**KIRKLEES METROPOLITAN COUNCIL
INVESTMENT & REGENERATION SERVICE**

Reference No:	2023/62/93255/W
Site Address:	15, Clara Street, Fartown, Huddersfield, HD1 6EN
Description:	Extension forward of the principal elevation and associated alterations (modified proposals)
Recommending Officer:	John Holmes

DECISION - REFUSED

Officer Report – 2023/93255

Drawing Title
Planning Drawing - Modified Proposals

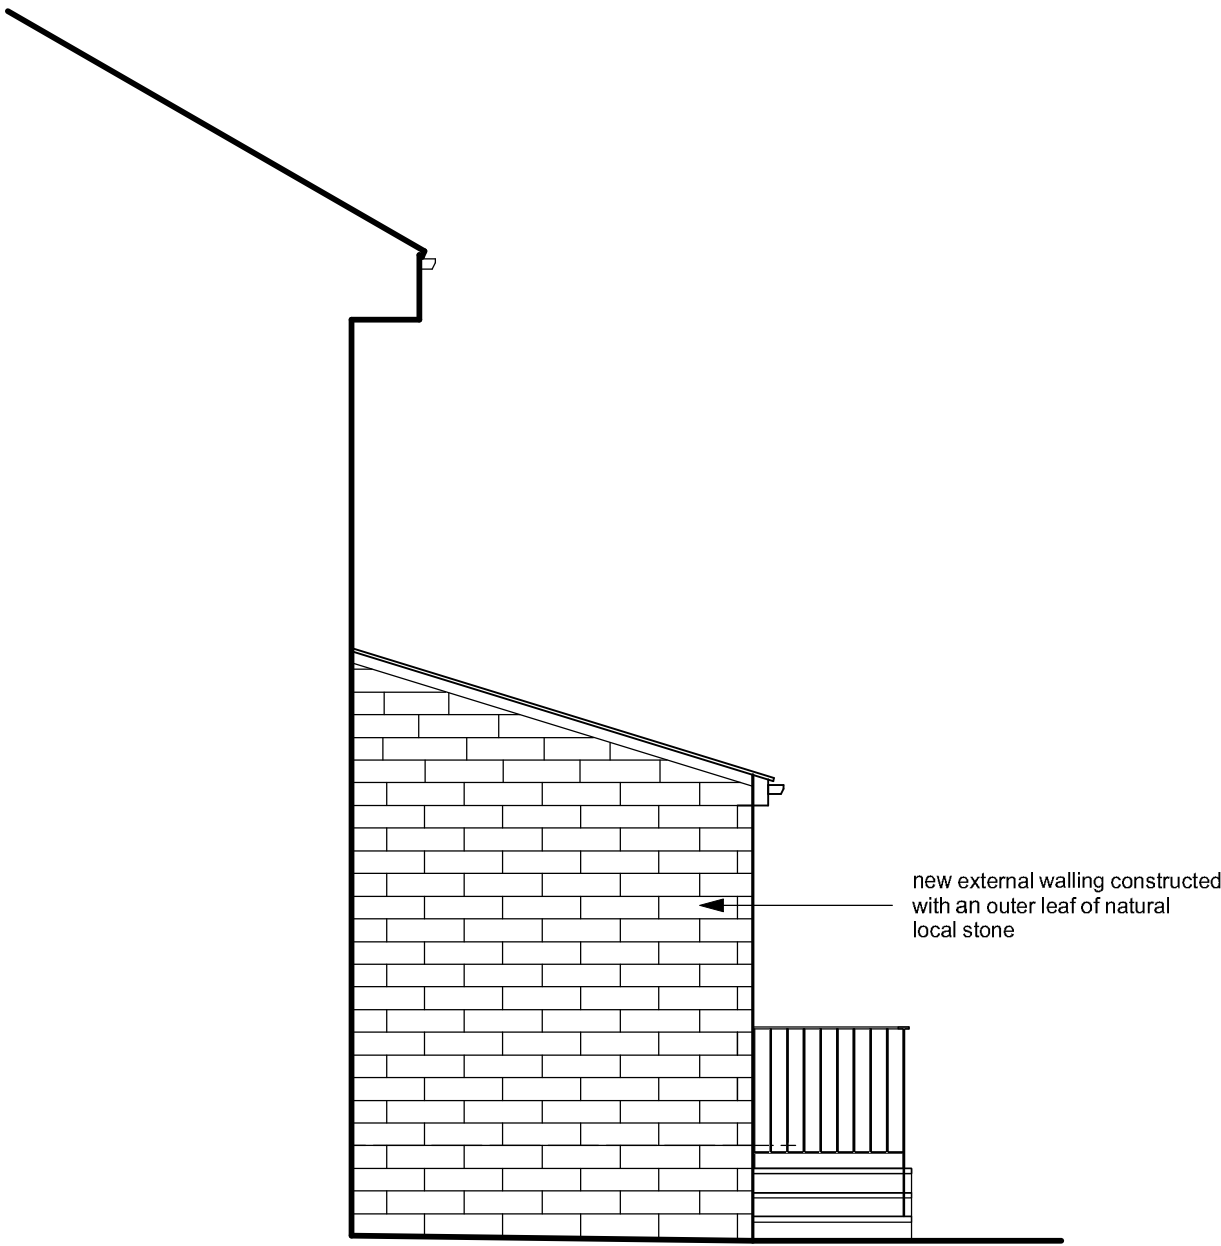
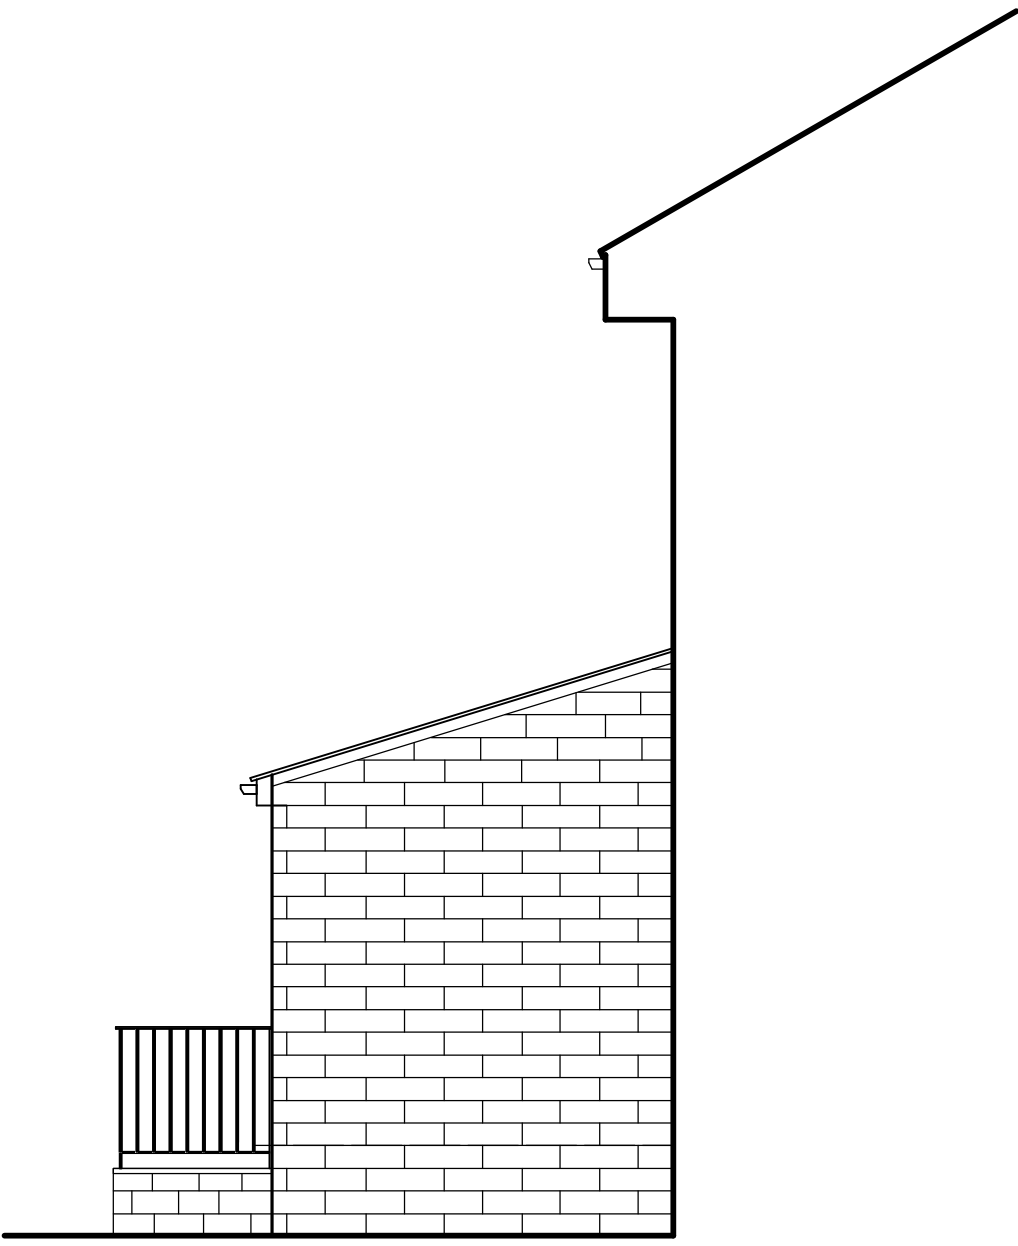
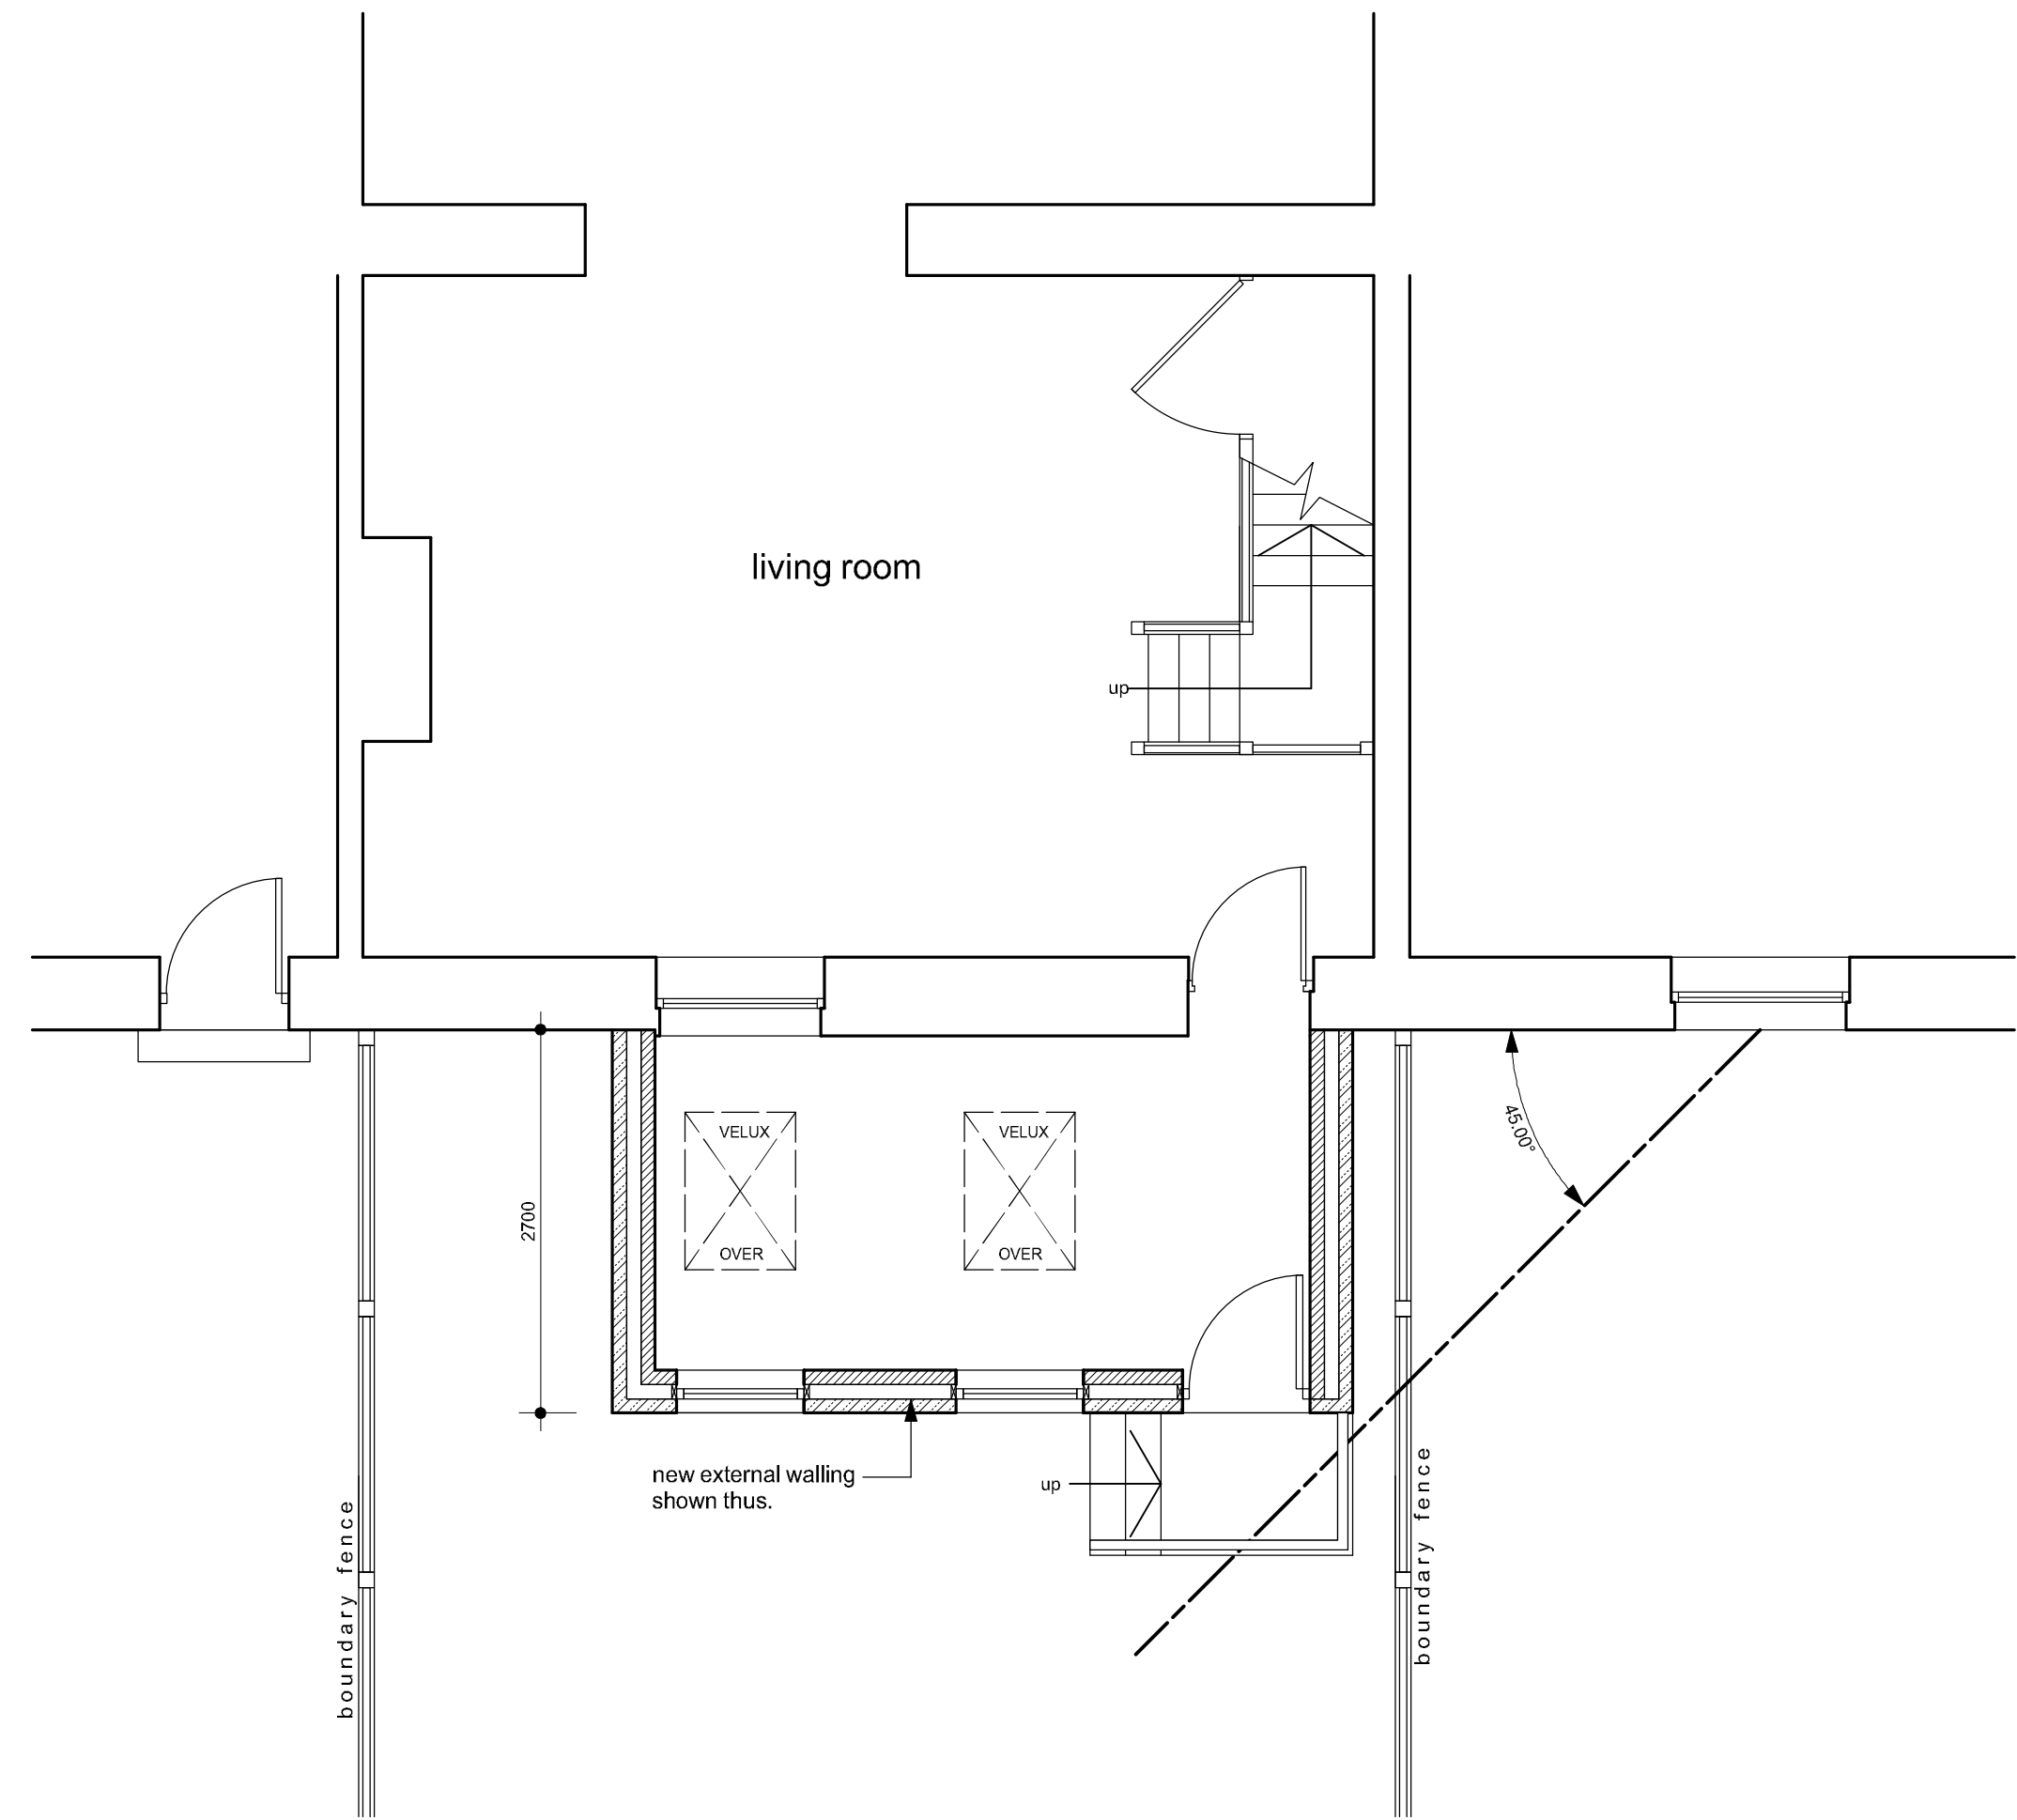
Whilst the proposal is to revise down the size and scale of an existing addition to the front, the proposal would still be a significantly sized addition which would have an out of character appearance when viewed in the context of the street.

It is noted that large amenity spaces to front are in place within the street, and the proposal would be set back from the road by 7m (approx) however it would be highly prominent being to the front and would have a significant impact on the character of this row of terraced properties whereby there are no additions to the front

The development would extend across the majority of the frontage of the ground floor and would see windows or proportions which are not in keeping with that of the host property. Notwithstanding this point it is considered the bulk and massing of the development would have a harmful impact in any case were the windows to be amended to a design in keeping with the host property.

It is noted the materials of construction would be in keeping with the host property and this element of reason no.1 of the previous refusal has been overcome. However it is considered the other elements of reason no.1 remain applicable given the substantial size of the proposal and its overall design taking account of its highly prominent location. In light of the size / scale of the proposal and fact it is likely only a much reduced scheme which sought a front extension of the scale of a porch could be supported, it was not considered appropriate to seek amendment to the scheme on that basis in this case and the application determined on the basis as submitted.

The existing structure as stands at site is glazed, which allows for views to be taken from the side elevations directly into that of neighbouring properties. The proposal would see windows to the front elevation only, and the raised platform is not considered to be of a scale which would be utilized for anything other than access to the entrance.

1. As a result of its design, scale and prominence within the street, the development would have a harmful visual impact upon the host property and the character of the wider locality introducing a development to the front which does not harmonise with the visual amenity of the host property and wider street scene. This is contrary to Policy LP24a and c of the Kirklees Local Plan, principles 1, 2 and paragraph 5.13 of the Council's House
